**Staged Commercial Precinct, Fifteenth Avenue, West Hoxton (SSD 6407)
Response to Submissions**

Thank you for your letter dated 15 August 2016 requesting Transport for NSW (TfNSW) comment on the above.

**Principal Manager, Land Use Planning and Development
Freight, Strategy and Planning**

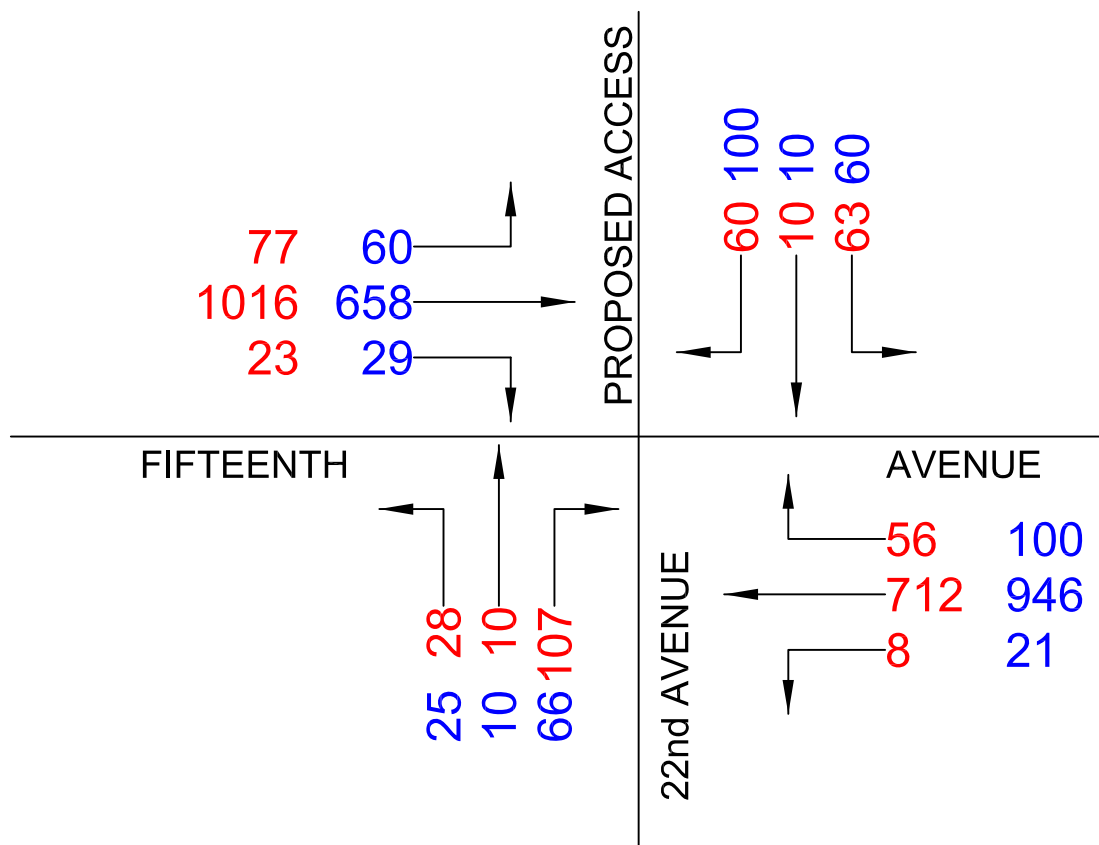
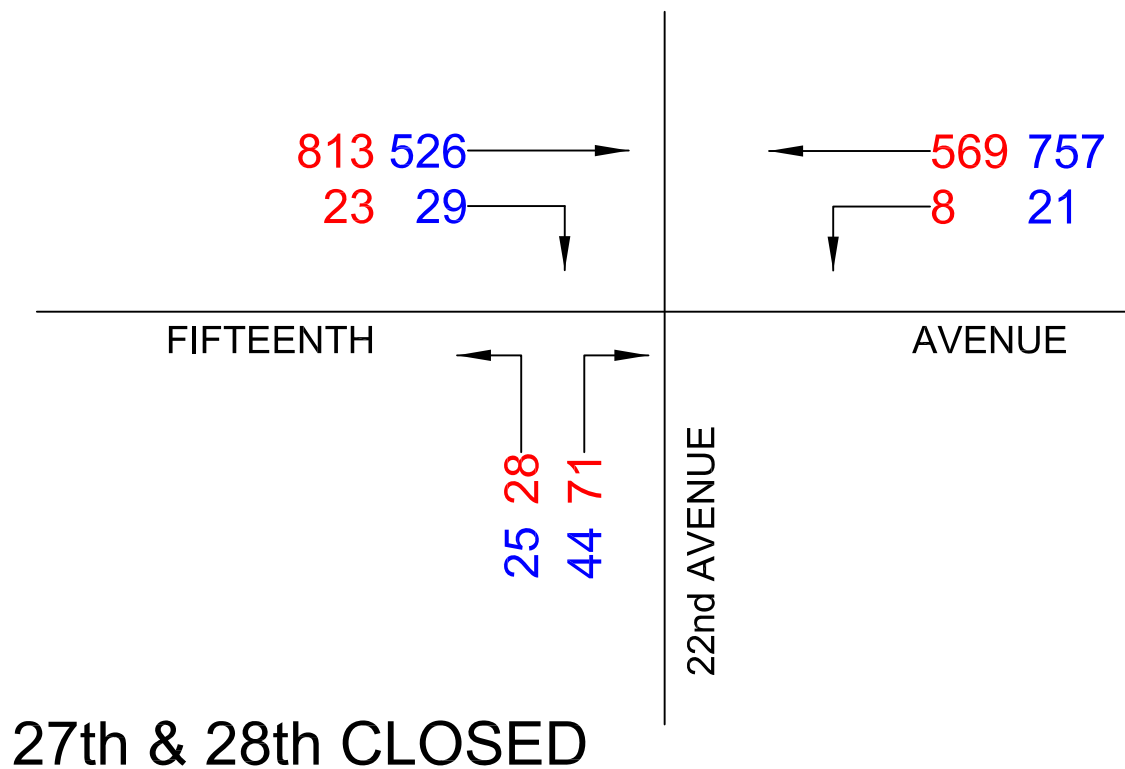
"RMS advised that a general width of 40m was required. There would be no difficulty in accommodating any additional width which may be required as RMS resolve the design detail."

TfNSW advises that a Bus Rapid Transit (BRT) route will be investigated between Liverpool and Campbelltown via Leppington using the existing Hoxton Park Road T-way, Fifteenth Avenue, Narellan Road and a new road alignment between Leppington and Oran Park as mentioned in the *Sydney's Bus Future*.

TfNSW requests that the proponent be conditioned to consult with Roads and Maritime Services and TfNSW to obtain the details of reservation area for Fifteenth Avenue to accommodate a BRT route.

“The applicant shall consult with TfNSW and Roads and Maritime Services to obtain the details of reservation area for Fifteenth Avenue to accommodate a BRT route, prior to submitting the Stage 2 Development Application.”
